Ref MJB/JB 22.05

Re: Erection of Commercial Building with Mixed Use; 1-3 Church St, Staincross, Barnsley, S75 6BU

Site Plan 1:200

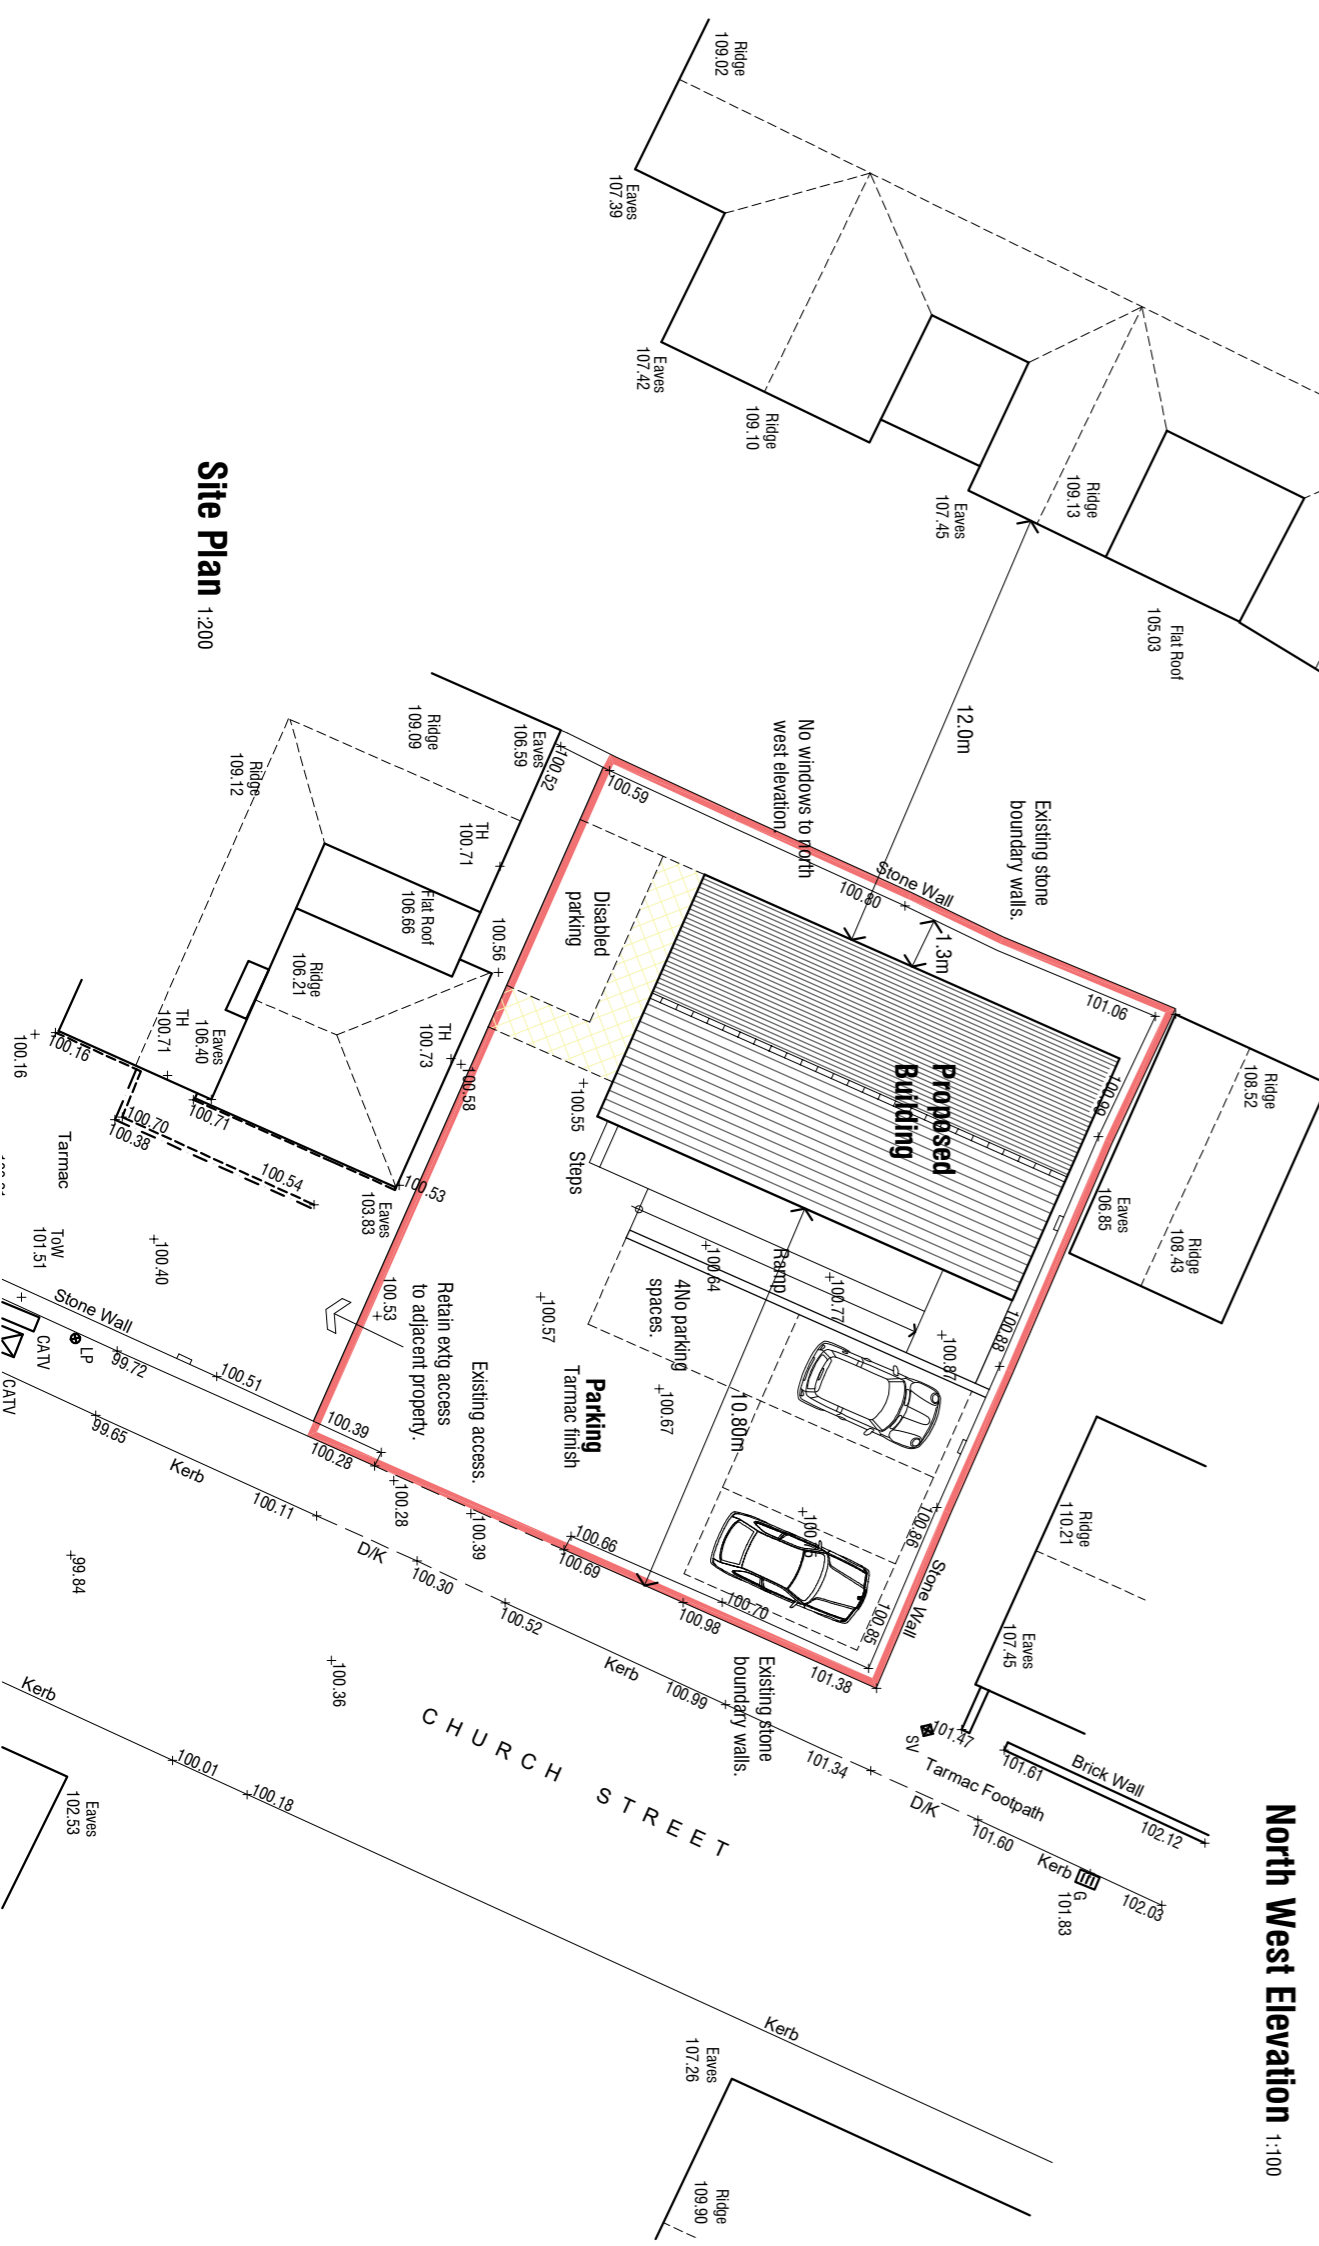
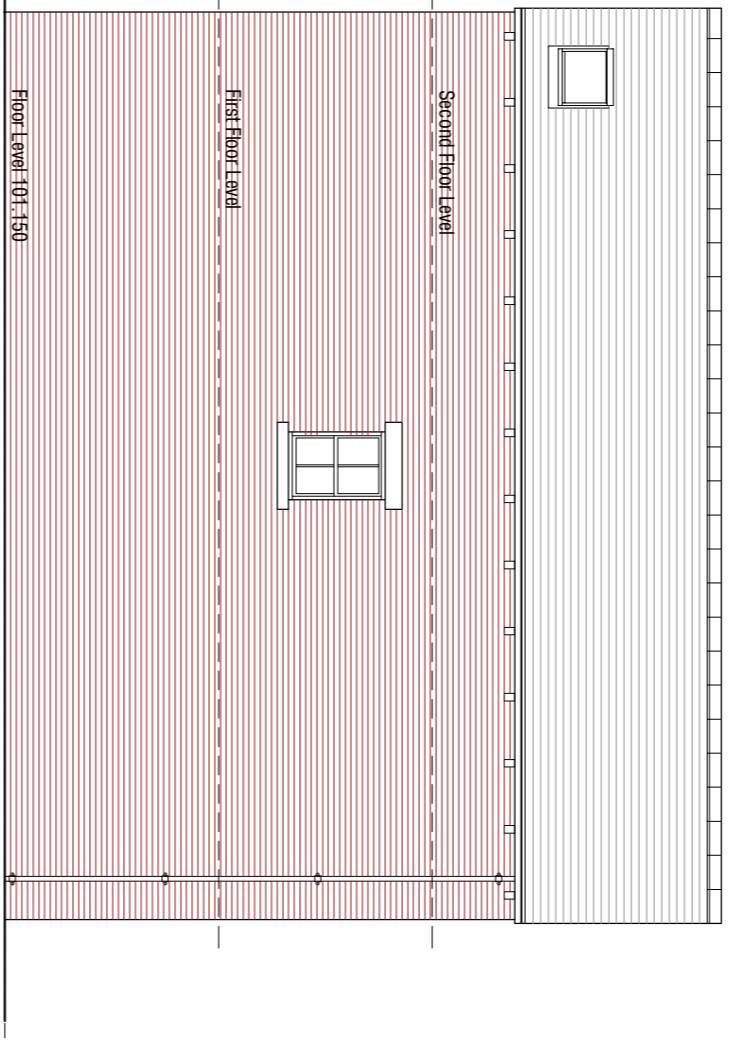
Highways comments state that the parking provision proposed for the proposed commercial building are acceptable to HDC officers, the development 'removes off-street parking provision for the existing business in the former police station.'

They have also stated that 'A funeral director, or another A1 use, would be highly likely to require off-street parking for company vehicles, staff, and customers.' This statement relates to an earlier planning application for Change of Use of the former police station to a funeral director, ref 2019/0177 when the council added the A1 designation to the approval notice.

Since the planning reforms in September 2020 funeral directors (and similar uses) are classified under Use Class E (Commercial, Business and Service) and not 'Non-Food Retail' as has been suggested. The parking requirement therefore is not one space per 20sqm but, can vary between 1 space per 10-35sqm. The site is in a highly sustainable location with excellent public transport links and therefore it is not unreasonable to apply a requirement for parking at the upper end of the scale, i.e. 1 space per 35sqm of floor area, resulting in a requirement for 6 spaces.

An amended Block Plan ref BP01 has been provided which shows the existing parking provision for the funeral directors (which is leased to them by the applicant). It demonstrates that they can accommodate 6 parking spaces within their land without the need to use the proposed development site. Two oversized spaces can be accommodated for funeral cars and a further four spaces can be allocated for staff and visitors. The applicant would also be willing to allow shared use of the disabled parking space shown on the application site for visitors to the Funeral Directors.
